Sent: 27 June 2022 15:59

I have given further consideration to the proposed two storey side extension. I have also reviewed the previous Conservation Officers comments again to see what detail has already been provided. We accept that the existing lean-to extension has seen previous alteration, which is noted by the addition of blockwork. However, looking at the photos at the time of listing the lean to was present, however the main change appears to be the degree of the pitch of the roof has been reduced with the addition of the block work. There is no record of the works being granted consent. This was shown in comments provide by the previous Officer on the 22 February 2021.

Proposed side elevation (1:100)

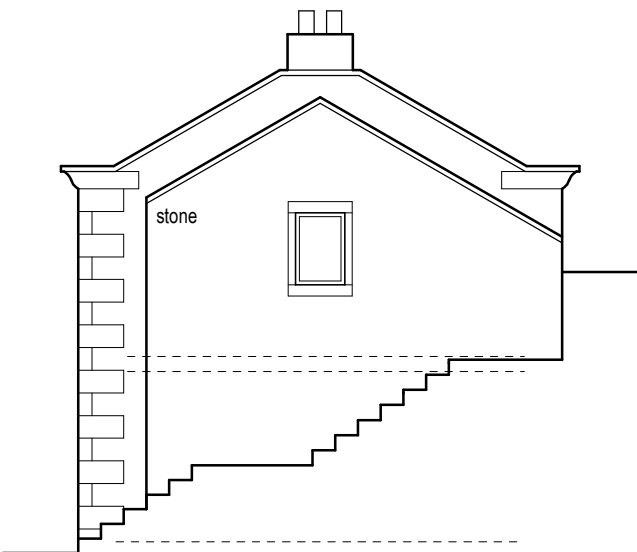
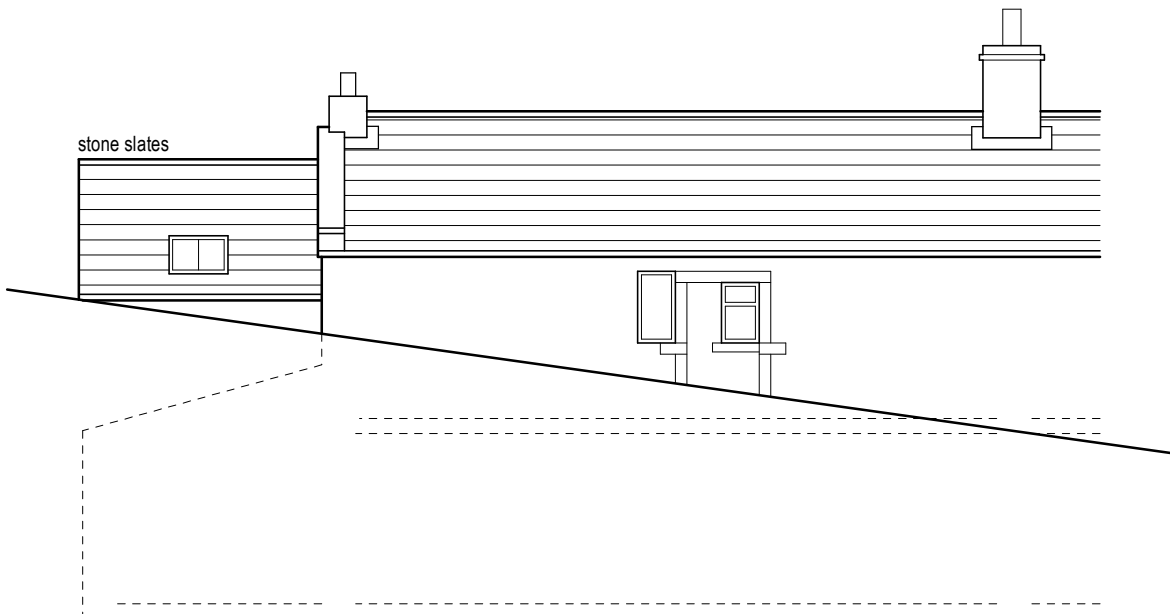
As discussed, the proposal would impact on the significance and character of the building, with the existing historic window openings being covered and the side elevation being altered, including creating a large opening for access into the proposed extension. This would also impact upon internal fabric and possible impact upon the chimney breast.

I have considered the options discussed when I met with you on site. However, I am unable to support the proposed two storey side extension. While details could be retained internally there would be a high degree intervention and alteration to the side elevation, which would not preserve or enhance the character of the building and would have an impact on the surrounding Conservation Area. While consideration has been given to material palette, this is not sufficient to mitigate against the harm.

As expressed by the previous Conservation Officer we could support an increase to the existing lean, bringing it forward along the elevation. This would be subject to further assessment of the significance of the existing lean to. With the increase of the lean to and some internal reconfiguration, you would have sufficient space to accommodate an addition room. While this would not allow for the two-storey extension, it would allow for an additional room.

As set out above, subject to further assessment of the existing single storey lean to be provided, we could accept an increased single storey extension increasing the footprint of the existing lean to extension. This would still allow for the additional room but have a significantly reduced impact to the building and Conservation Area. We are unable to support the proposed two storey extension. I have copied in the Planning Officer Sam Jackman, so she is aware of discussions.
